Re: Certification Submittal for Certificate of Occupancy for
Vistas de la Luz Commercial Development PHASE 1, 5400 Sevilla Ave NW
DRB Site Plan, Project # 1004675 (F11-D010A)
Certification dated 05-04-09

**Re: Vista de La Luz Commercial Amended Grading and Drainage Plan
Engineer's Stamp dated 4-7-09 (F11/D010A)**

**Re: Vista de La Luz Commercial Grading and Drainage Plan
Engineer's Stamp dated 6-19-08 (F11/D010A)**

**Re: Vista de La Luz Commercial Grading and Drainage Plan
Engineer's Stamp dated 4-10-08 (F11/D010A)**

SITE PLAN FOR BUILDING PERMIT

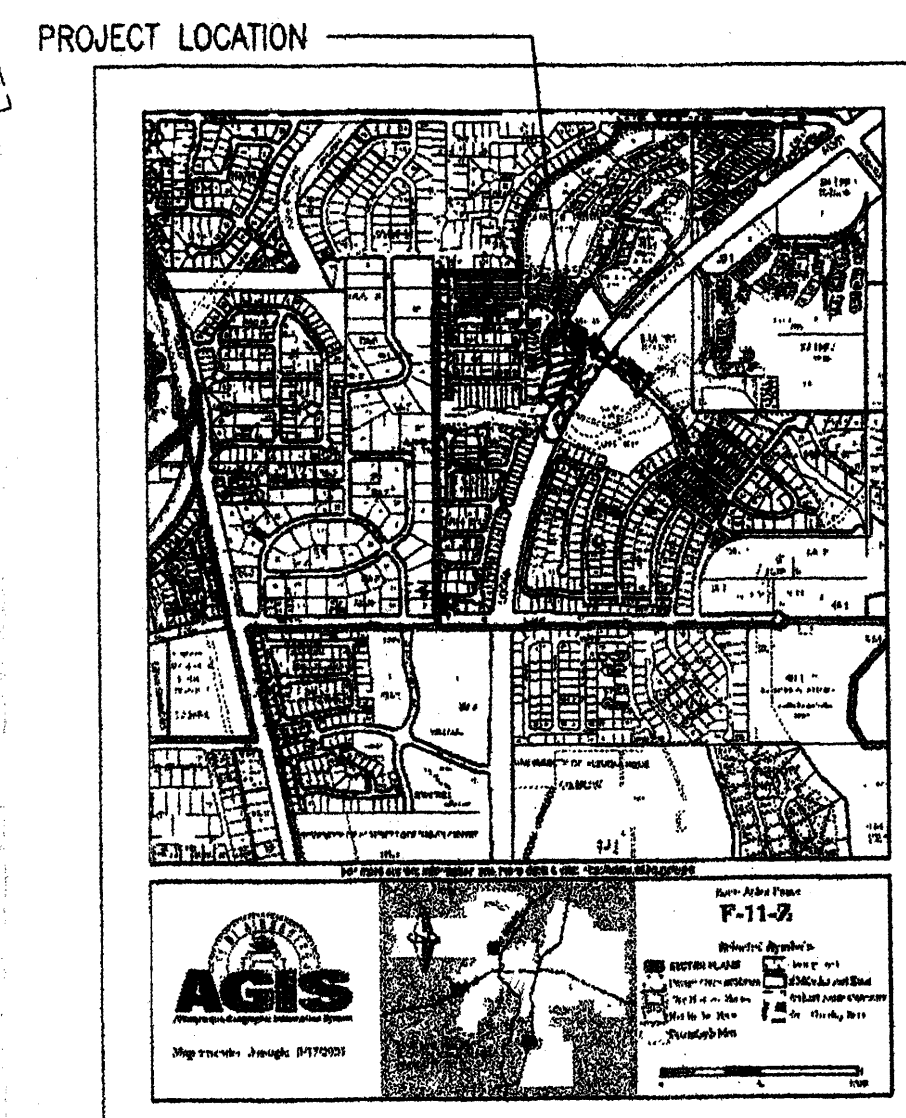
- Dumpster pads for restaurants are required to drain to the sanitary sewer after passing through the grease trap.
- Specify the means/provide a detail for stabilizing the 1:1 slope along Coors Blvd.
- What is the status of the storm drain in Coors Blvd?
